KIRKLEES METROPOLITAN COUNCIL INVESTMENT & REGENERATION SERVICE

Reference No:	2026/70/91000/E
Site Address:	44, Fall Lane, Hartshead, Liversedge, WF15 8AR
Description:	Variation of condition 2 (plans) on previous permission 2025/92323 for demolition of existing garage and erection of replacement detached garage and two storey side extension
Recommending Officer:	Faiza Bano

Officer Report

Drawing Title
**DETACHED DOUBLE
 GARAGE**

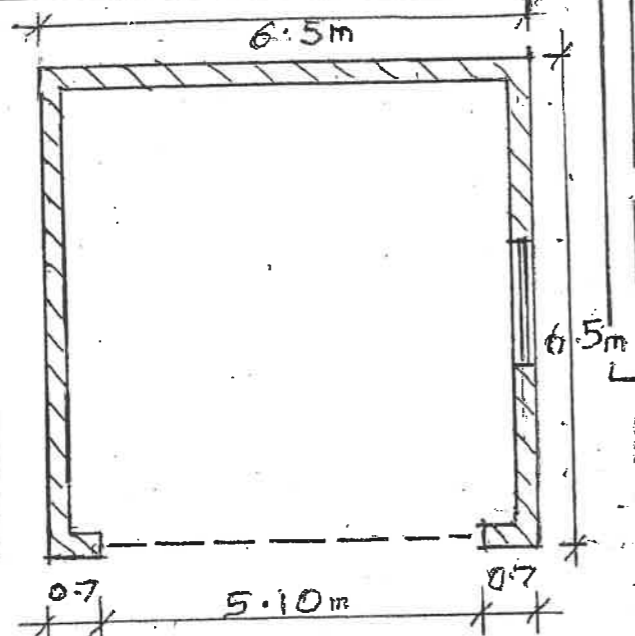
The current application seeks to vary Condition 2 (approved plans) to allow for the repositioning of the garage door, the lowering of the garage by approximately 1.6m and an increase in wall height to 3m. The application form confirms that the roof pitch would remain unchanged at 20 degrees.

The repositioning of the garage door is a minor amendment which would not materially alter the appearance of the building within the street scene. Similarly, although the wall height would increase to 3 metres, the garage would be lowered by approximately 1.6 metres into the site. As a result, the perceived scale and prominence of the structure would not materially increase and may appear reduced when viewed from surrounding land and public vantage points due to the site's sloping topography.

The repositioning of the garage door would not introduce any additional impacts upon neighbouring residential amenity. Whilst a new window is proposed within the south-east elevation of the garage, for the reasons set out above it would not result in an unacceptable loss of privacy or overlooking. The proposal therefore raises no concerns in relation to privacy.

The amended plans also show the introduction of a window within the south-east elevation of the garage facing towards number 46 Fall Lane. Given that the window would serve a non-habitable domestic outbuilding, rather than a principal living space, opportunities for overlooking would be limited. Furthermore, the garage would remain separated from number 46 by the existing garden areas and boundary treatments. Having regard to the nature of the accommodation served and the relationship between the properties, the proposed window would not result in an unacceptable loss of privacy to the occupiers of number 46 Fall Lane.

Whilst the height of the garage walls would increase, the building would also be lowered by approximately 1.6m into the site. As such, the apparent height and visual presence of the garage when viewed from neighbouring properties would not materially increase. The approved report noted that the garage would be located approximately 9m to 13m from neighbouring properties at numbers 36 and 38 Fall Lane and at a lower topographical level than those dwellings. These relationships would remain broadly unchanged. Given the proposed lowering of the structure, it is not considered that the amendments would give rise to any materially greater loss of light, overshadowing, overbearing impact or loss of outlook than the already approved scheme.

4. The garage hereby approved shall be finished in render and the roof covered in materials matching the approved plans unless otherwise agreed in writing by the Local Planning Authority.
